Project Name: Newcastle Courthouse Redevelopment | Nihon University

Reference: 17-0347 memo 26 – 11.07.2019

### 26 SSD-9787 Nihon University Newcastle Campus – Urban Design Response

Design Option Studies-1 : Facade Design Scatter Diagram

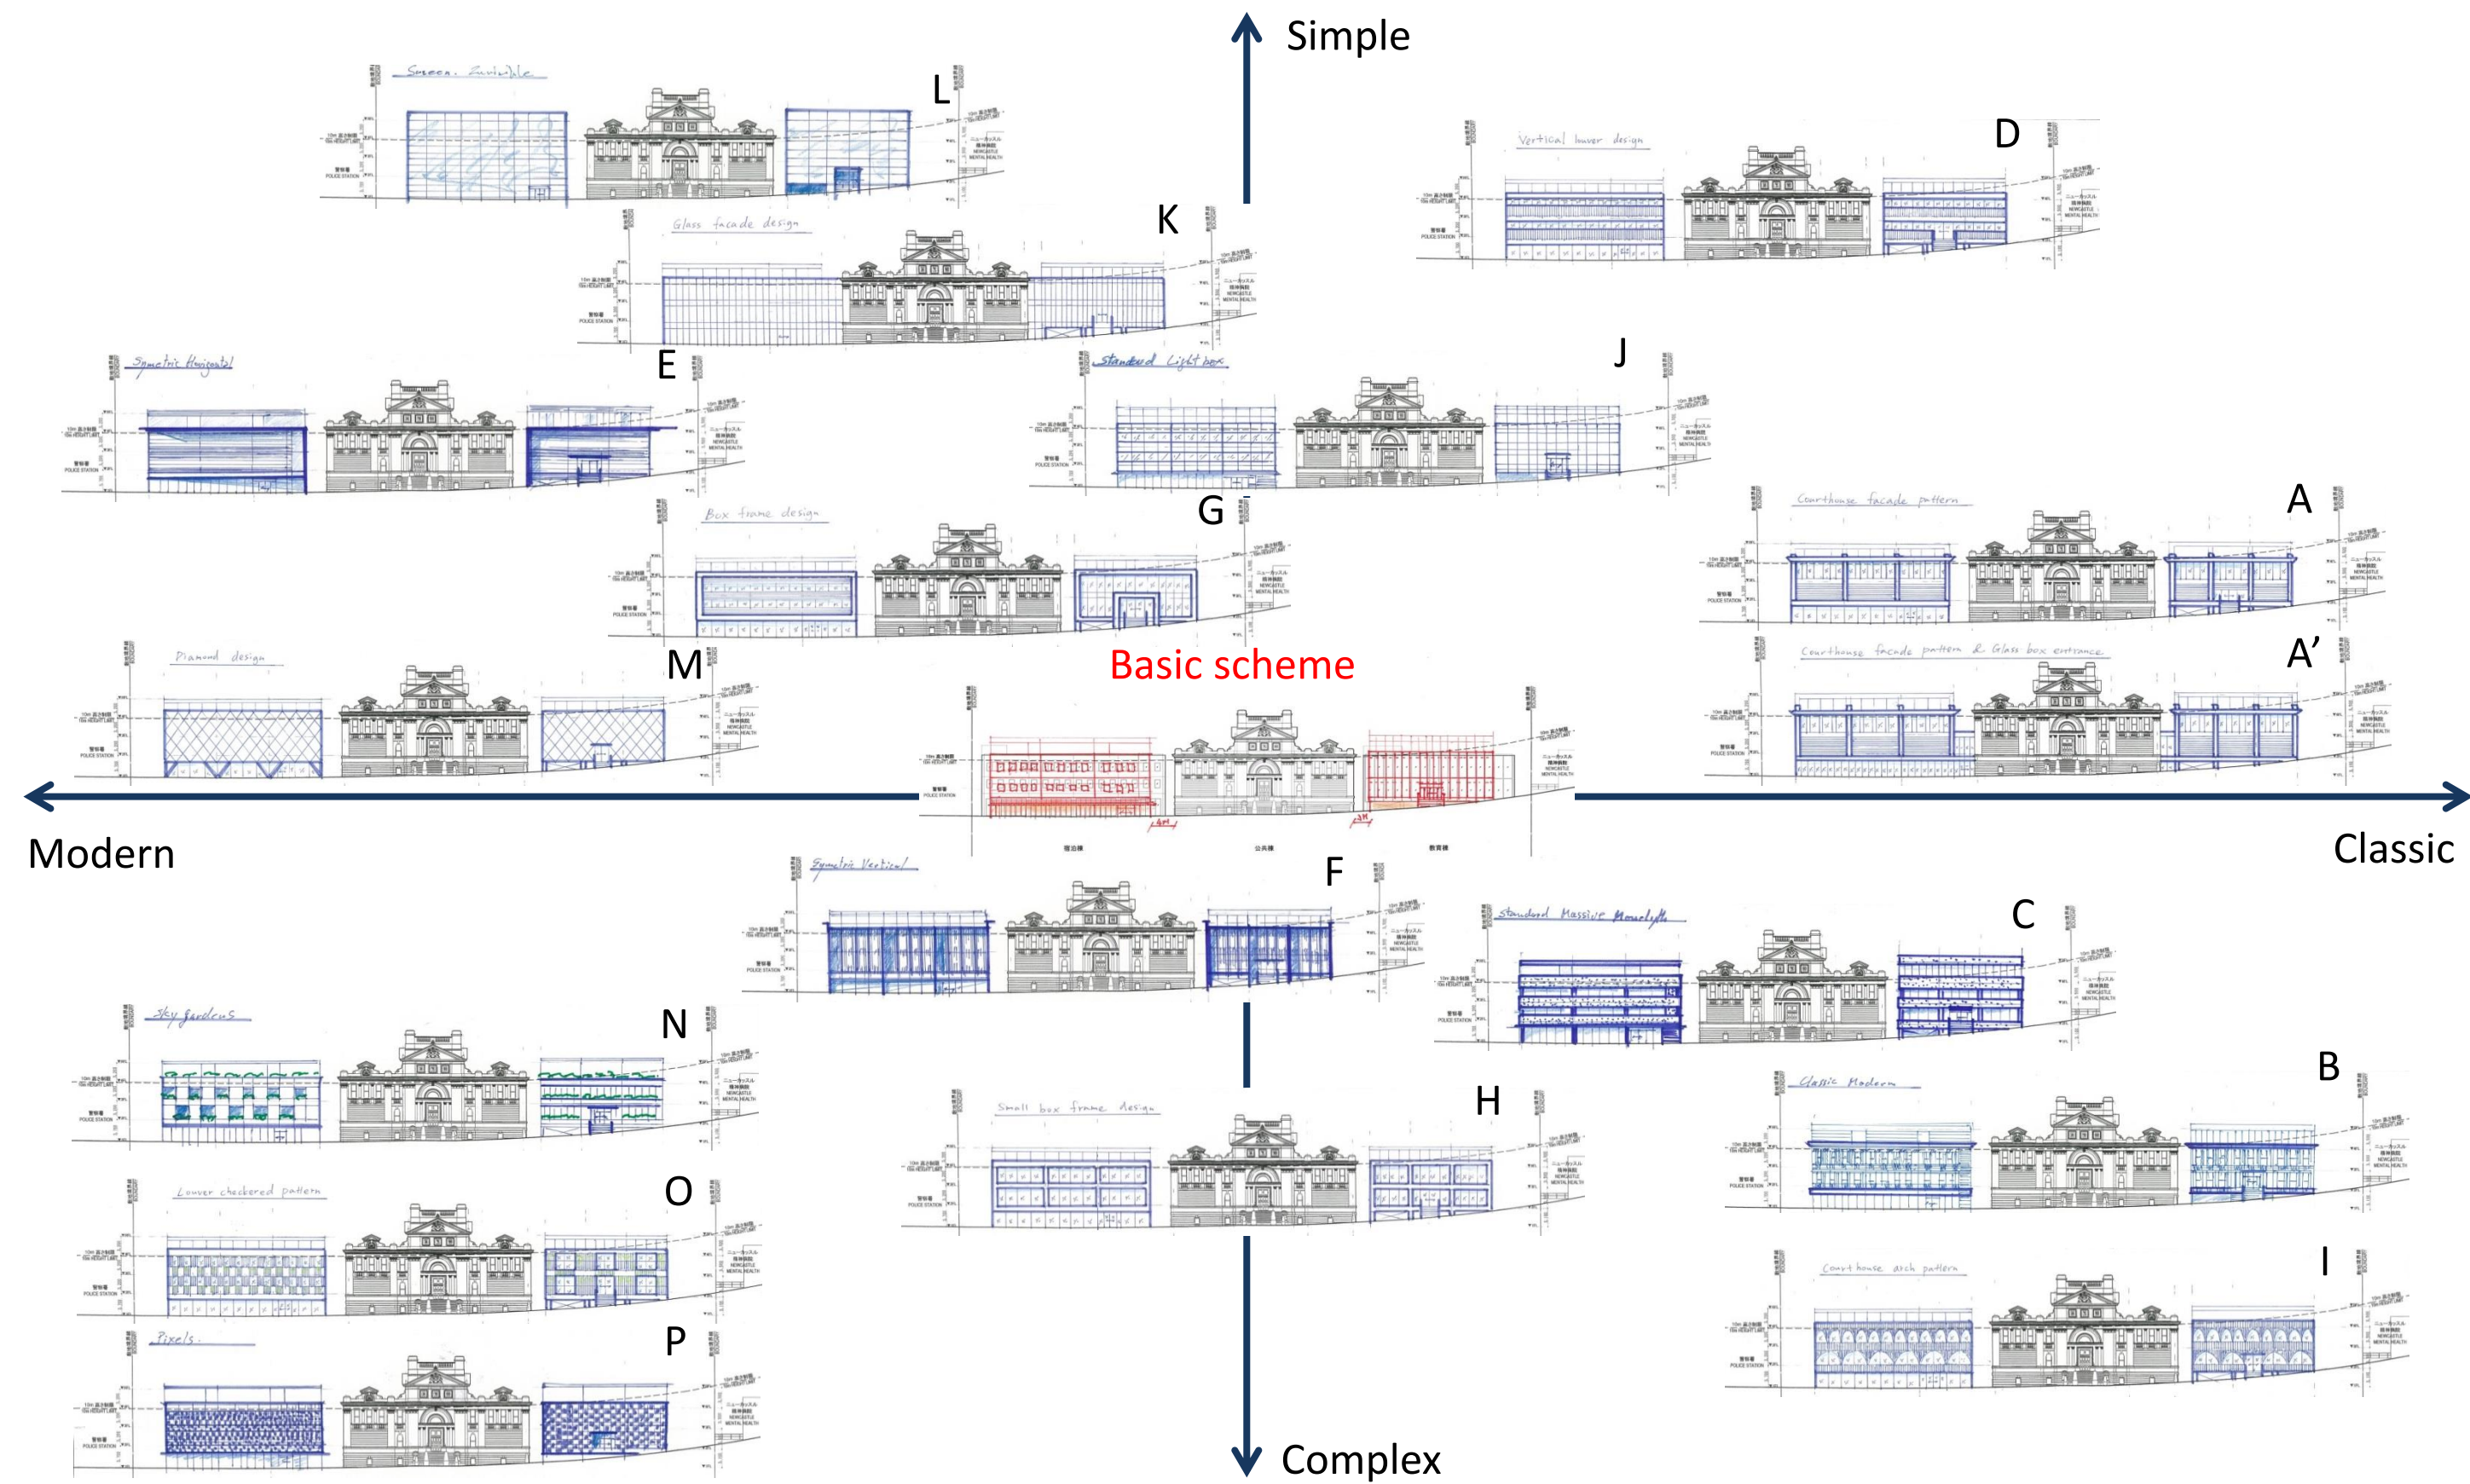
1. *'The proposed buildings have a strong horizontal massing which is not in keeping with the character of the courthouse, or the urban fabric of this part of the city (look at the proportions of the terraces on Church Street). A combination of horizontal and vertical massing is needed in the façade to be a better fit with the area.'*

2. *'The façade expression is relatively similar for both the dormitory and the teaching buildings. While the two should (as the architects propose) have a similar language of texture, colour and materiality, the UDCG suggests that the next stage the different functions of the two could be expressed. As such, a smaller scale, richer façade might be found in the dormitory building, while a slightly larger scale, more commercially expressed version of the façade might be developed for the teaching building.'*

In response to the above point 1, the facade design of the two new buildings either side of the existing historic courthouse has been refined to provide a mix of both horizontal and vertical detail elements to respond the varying character of the neighbouring built environment.

In particular, banks of vertical blades on each of the new buildings divides their frontages and reduces the apparent length of their overall profiles while giving definition to their elevations and echoing the proportional breakup of the former courthouse facade. As well, the vertical blades in conjunction with their horizontal battened

In response to the above point 2, the facade design for the two new buildings either side of the existing historic courthouse has been varied so that they each appear different in detail yet maintain a similar architectural language.

The refined design has arranged the break-up of the banks of vertical blades on the eastern dormitory building as similarly proportioned facade elements, while the design on the western teaching building presents the vertical blades as column-like elements along the length of the facade. The equally proportioned break-up to the eastern building elevation reflects a more enclosed and protected frontage along with punch window fenestration for the residents of the dormitory, while the broader position of the column blades and large commercial style glazing on the western building demonstrates the open nature of the learning environment within.
